Our Case Number: ABP-309770-21

Re: Proposed development of up to 15 wind turbines with a tip height of up to 175 metres and laying of approximately 26km of underground electricity cabling to facilitate the connection to the national grid, and all associated site development works
Townlands of Camagh, Carlanstown, Coole, Clonrobert, Clonsura, Doon, Monkstown, Mullagh, Newcastle and other townlands, Co. Westmeath

Case reference: PA25M.309770

Submitters: Ruth Sweeney/ Adam Sweeney

Figure 13-11: Proposed road to T15 in relation to newly recorded potential archaeological monument.

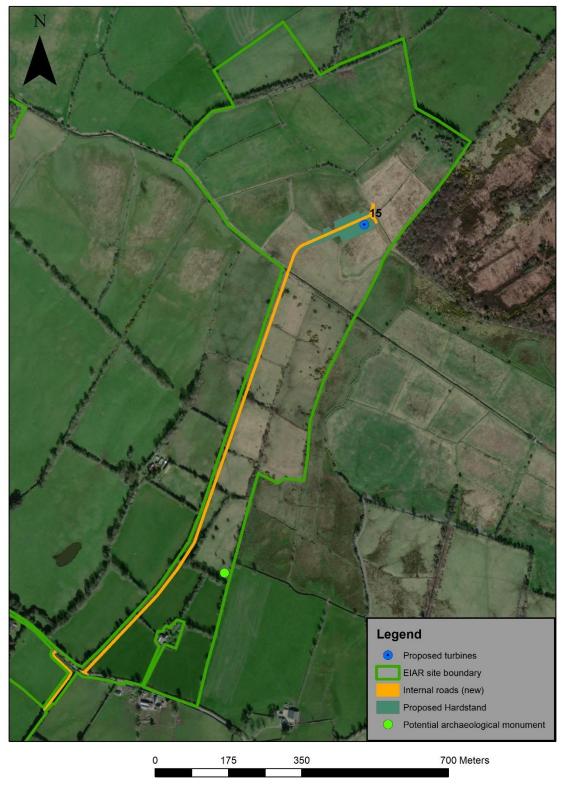
There are no mitigations referred to in regards to archaeology. This is an archeologically rich area. Proposed Turbine no.2 is situated right beside a crannog. What will be done to protect this crannog? There is an archaeological ridge situated right beside Turbine no 15. No mitigations mentioned to protect this either. If this was a domestic build a full archaeological dig would be insisted upon prior to any building work, at considerable expense. Why not here?

Figure 8. Link 1 - Closeup Plan View (Multyfarnham to Slieve Glah)

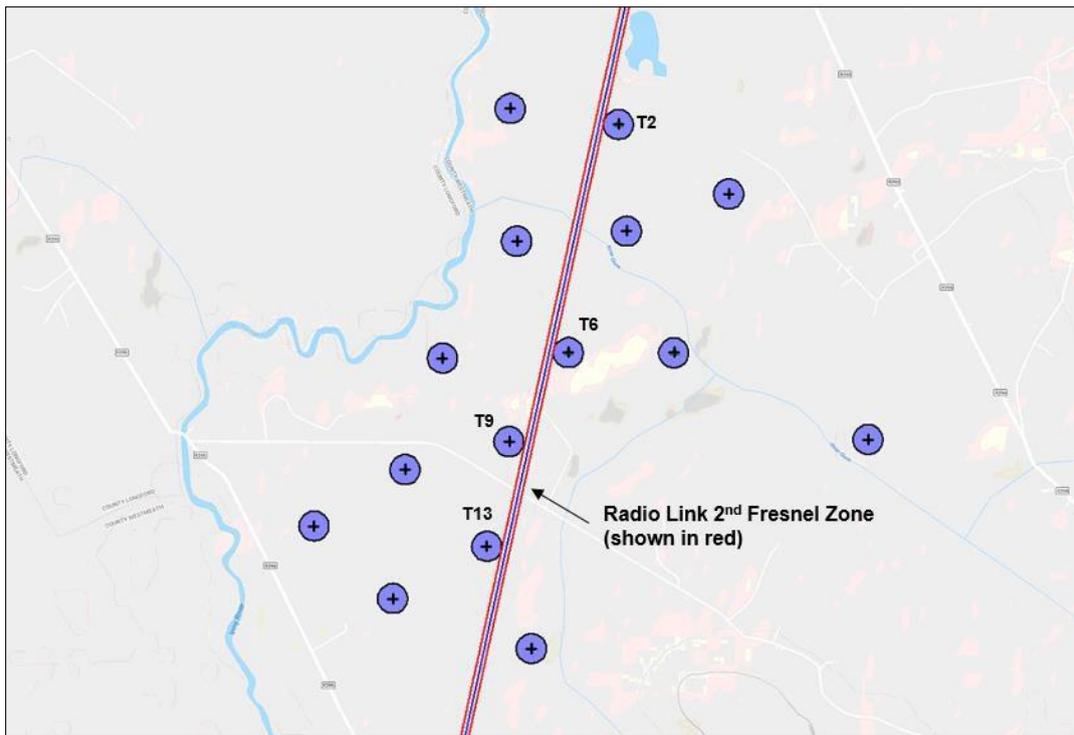
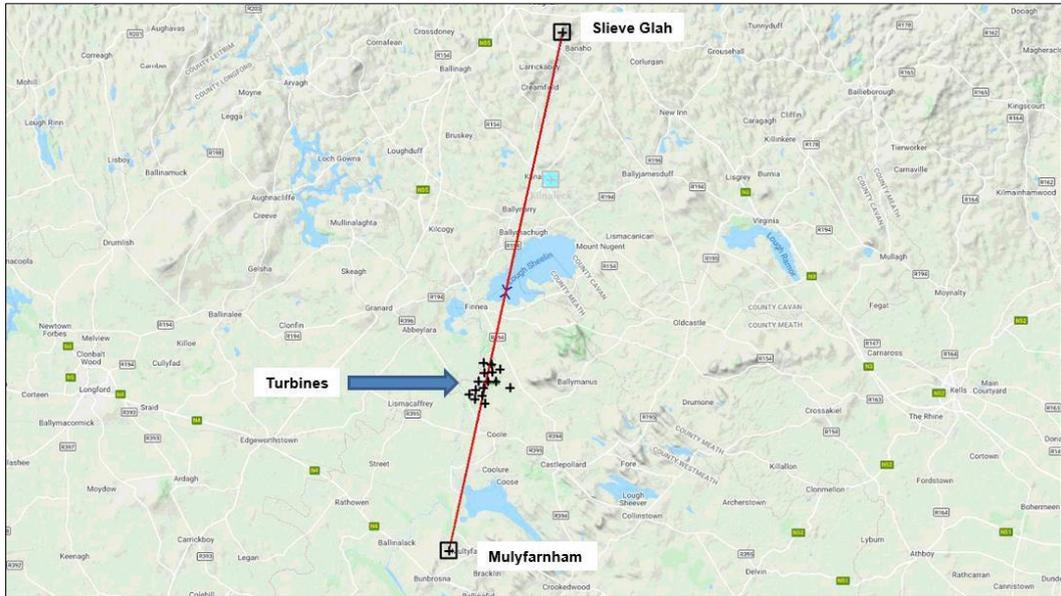
- 16) In fig. 3.2 it appears that turbines 2, 6, 9 and 13 are in the path of the buffer zone for Three Ireland. Three Ireland has the best mobile phone connection in this area. It is not good, but is the only viable one locally. This now is to be destroyed by the turbines.

- 17) Remote working will be impossible in this area if the currently fair internet coverage is degraded by blockage from the turbines.
- 18) Turbine no 11 is just within the buffer zone of at least one residence.
